# SUNNICA ENERGY FARM

8.44 Applicant's Response to Local Impact Report – Response to  
Annex E and Annex F

<b>Version</b>	<b>Date</b>	<b>Status of Version</b>
Rev 00	28 November 2022	Deadline 3A Submission

SUNNICA EAST SITE B,
SITE ACCESS D & H (SE-D) & (SE-H)
NEWMARKET ROAD (SHEET 2 OF 2)

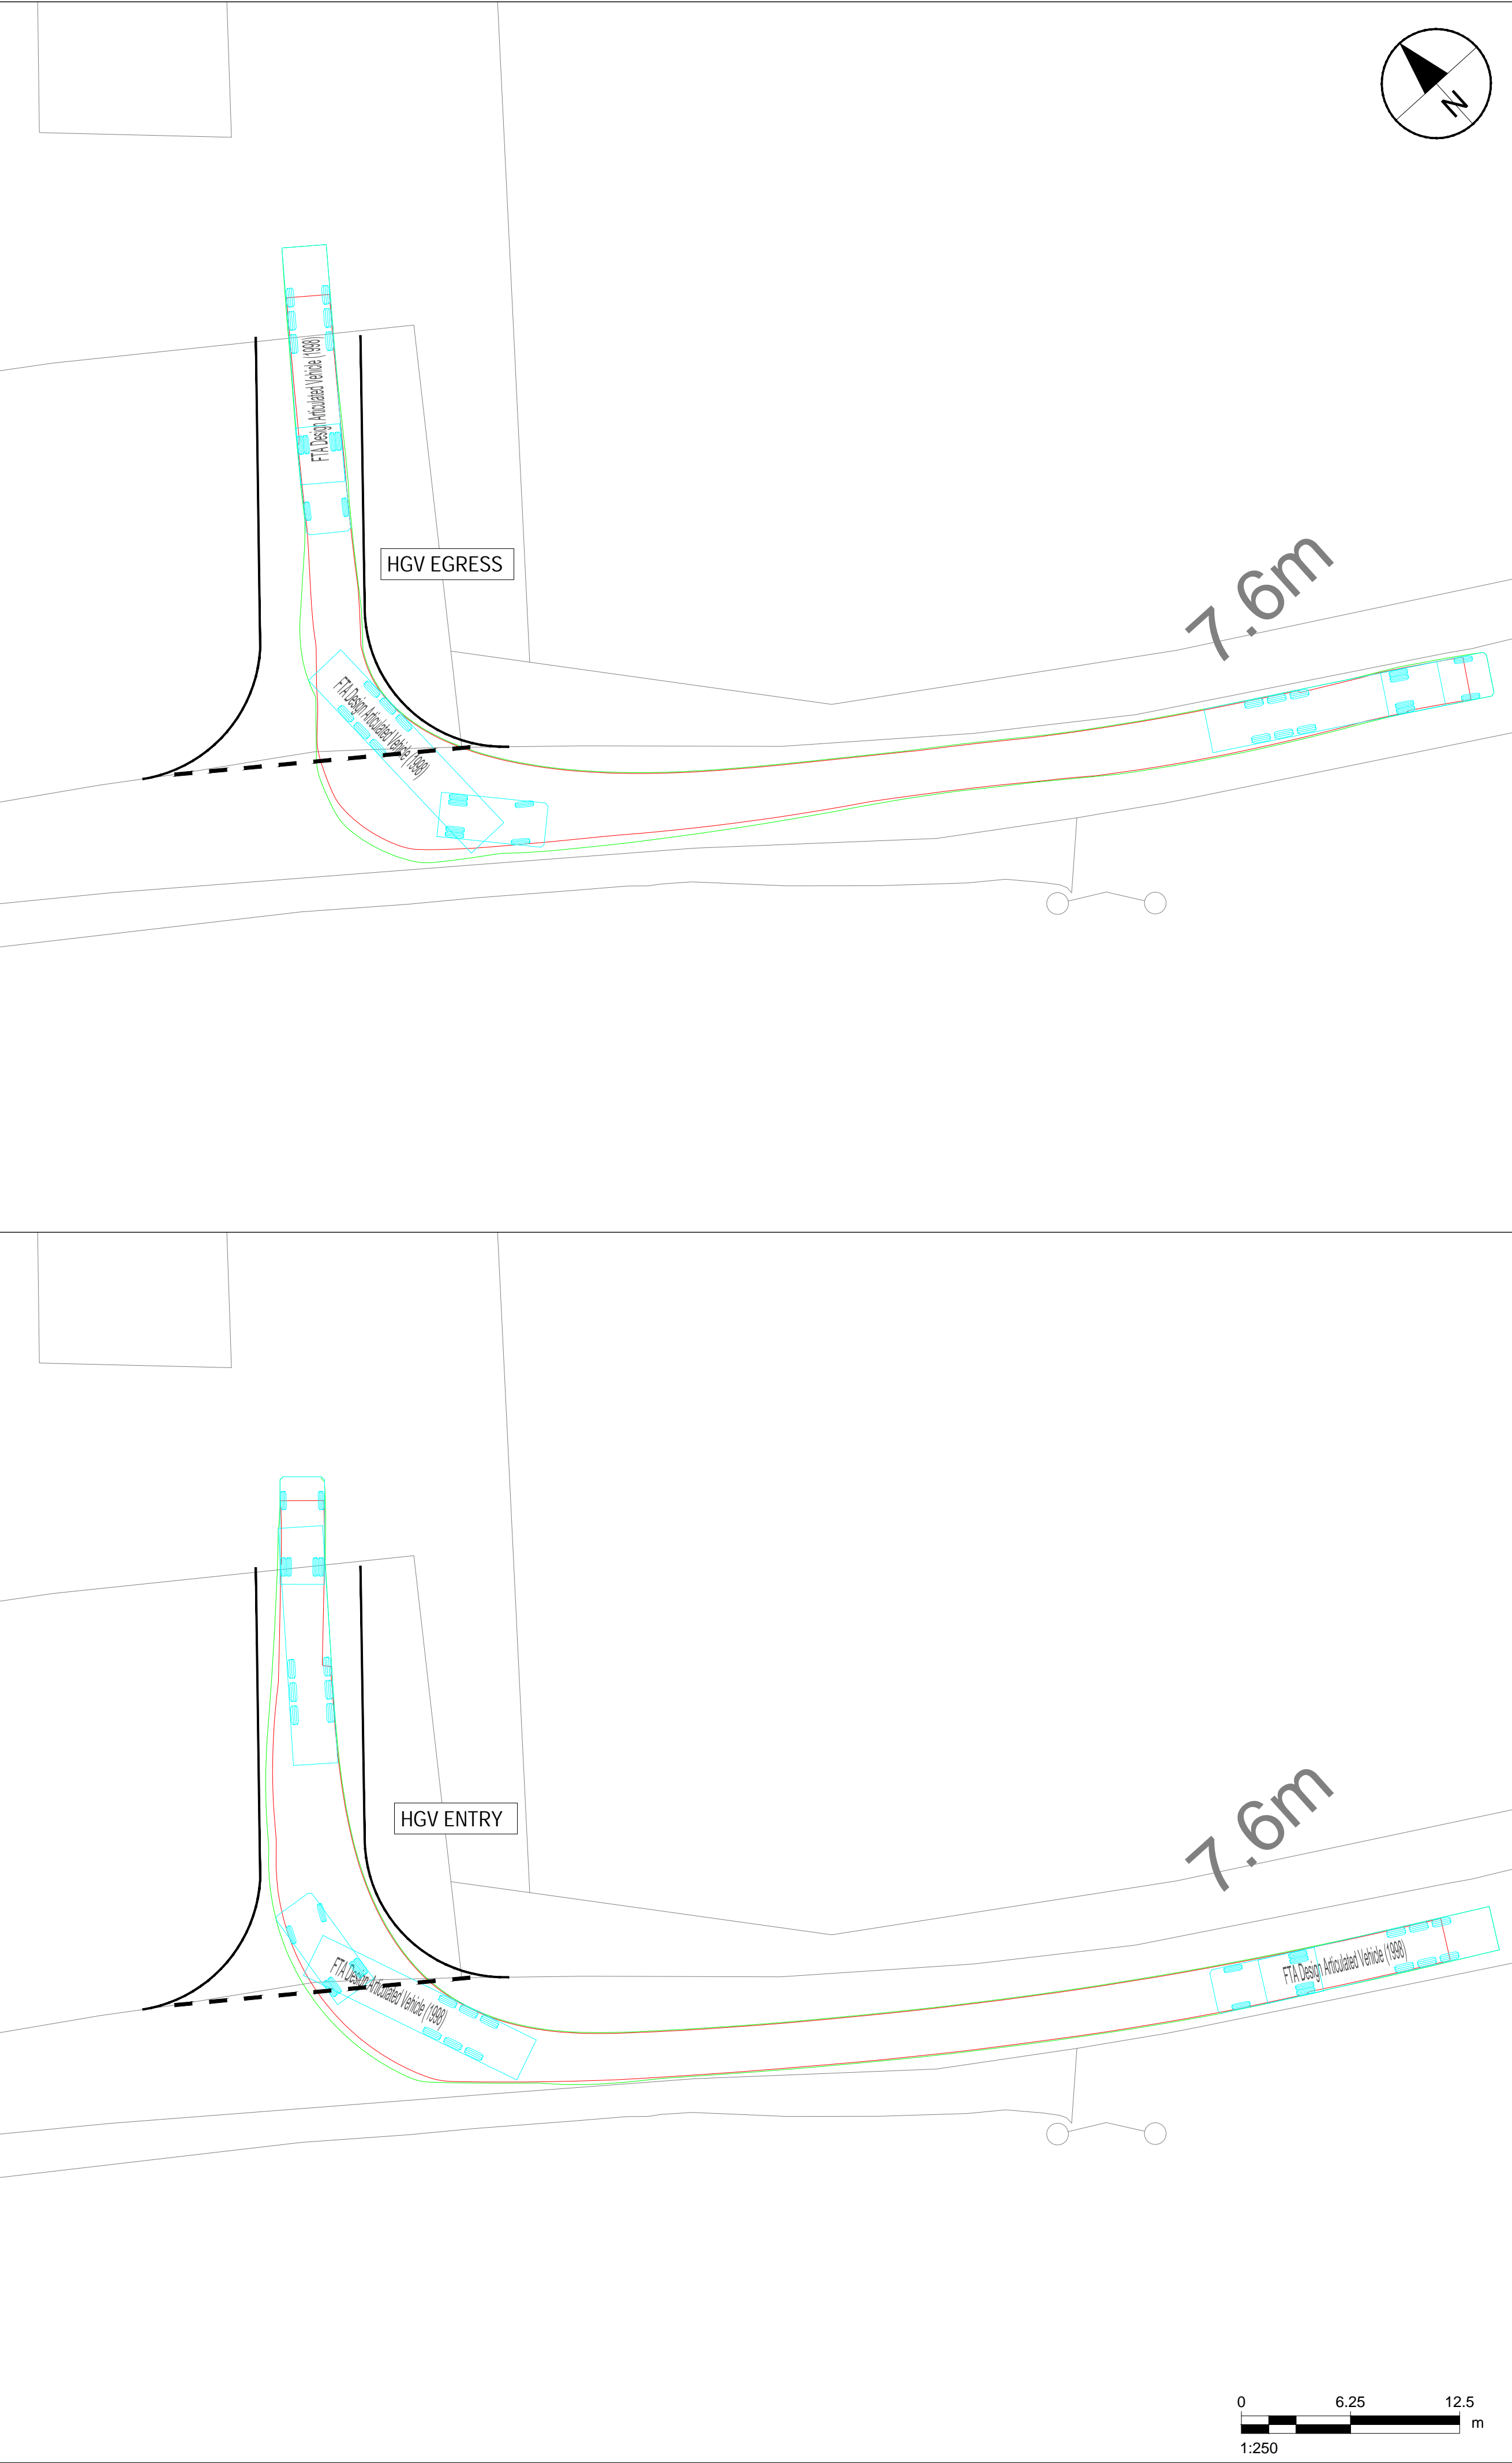
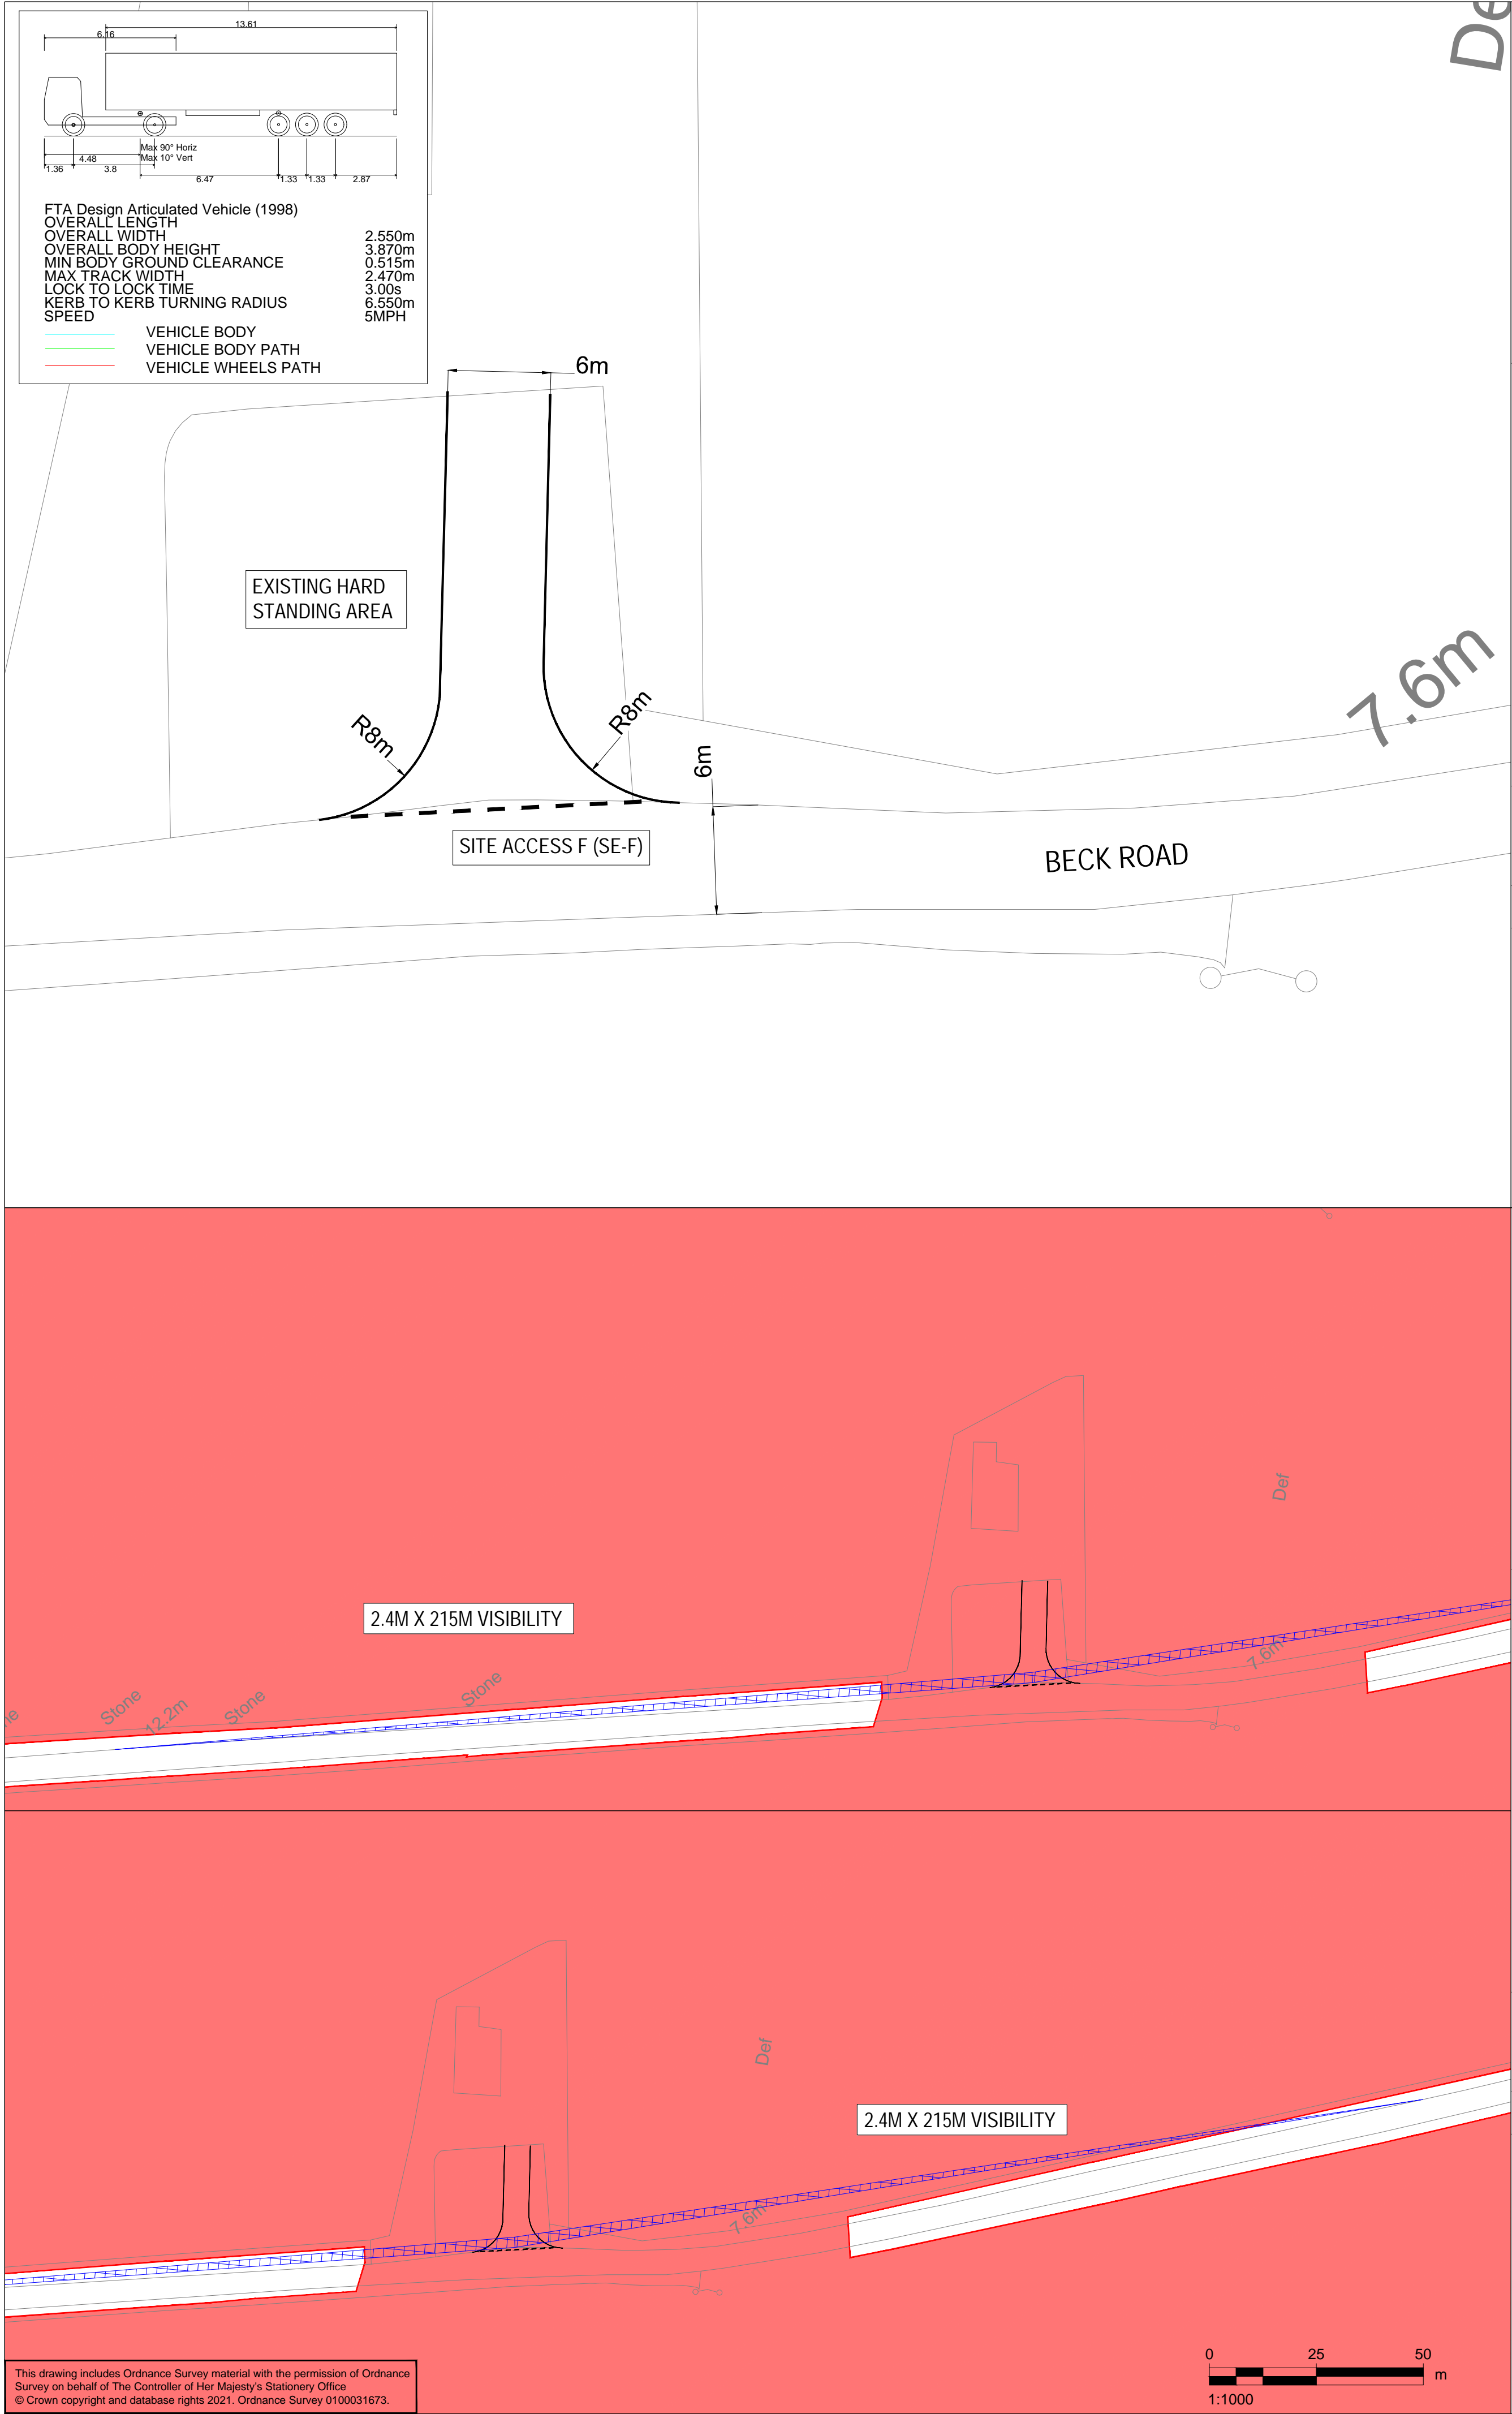
E.45-E.48	Comments on Individual Accesses Sunnica East Site B: Site Access D on C610 Newmarket Road	<p>Please see the response to E.14-E.19 in terms of the draft set of site access drawings to be provided within the next iteration of the Framework Construction Traffic Management Plan and Travel Plan [AS-300, AS-301] that the Applicant proposes to submit at Deadline 3, and a summary of the position in relation to design at this stage and detailed design. The</p>

LIR Summary Reference (Para)	Summary of LIR Comment	Applicant's Response to LIR
		<p>potential discrepancy raised in E.48 will be investigated, and the F-CTMP/TP site access drawings will show the correct location. An indicative amount of vegetation clearance is shown within the site access drawings which are included within the the Framework Construction Traffic Management Plan and Travel Plan that the Applicant proposes to submit at Deadline 3A.</p> <p>The Traffic Regulation Measures Plan – Temporary Measures [REP2-007 to REP-011] identifies that it is proposed to include temporary traffic signals and temporary speed limit reduction along Newmarket Road along with a signage strategy to warn motorists of the upcoming temporary traffic signals and construction site access. This addresses the request for traffic management in E.47.</p>
E.49-E.55	Comments on Individual Accesses Sunnica East Site A: Site Access E on Ferry Lane (Formerly Freckenham Road)	<p>The site access E located on Ferry Lane (Freckenham Road NSRN 14601046) is proposed to be used during the construction, operational and decommissioning phases. During the construction period the site access will be used by HGVs, during the operational period the site access will be used by the occasional staff for maintenance for accessing the substation purposes and during the decommissioning period the site access will be used by HGVs.</p> <p>The swept path analysis has been provided for a 16.5m articulated HGV from the direction of travel which is identified on the construction routes. Therefore, vehicles would not use the northern part of the triangular access. The site access will be managed throughout the construction phase therefore removing the requirement for two-way HGV movements, with management measures set out in the Framework Construction Traffic Management Plan and Travel Plan ].</p> <p>Please see the response to E.14-E.19 in terms of the draft set of site access drawings to be provided within the next iteration of the Framework Construction Traffic Management Plan and Travel Plan submitted at Deadline 3A, and a summary of the position in relation to design at this stage and detailed design.. This will provide clarification regarding paragraphs E.53, E.54 and E55.</p> <p>Access K located on Beck Road will be used during the construction and decommissioning periods for AIL access and for emergency access during the operational period. Site Access E will be used for access to the substation. This is identified within Figure 3 within the Framework Construction Traffic Management Plan and Travel Plan].</p>
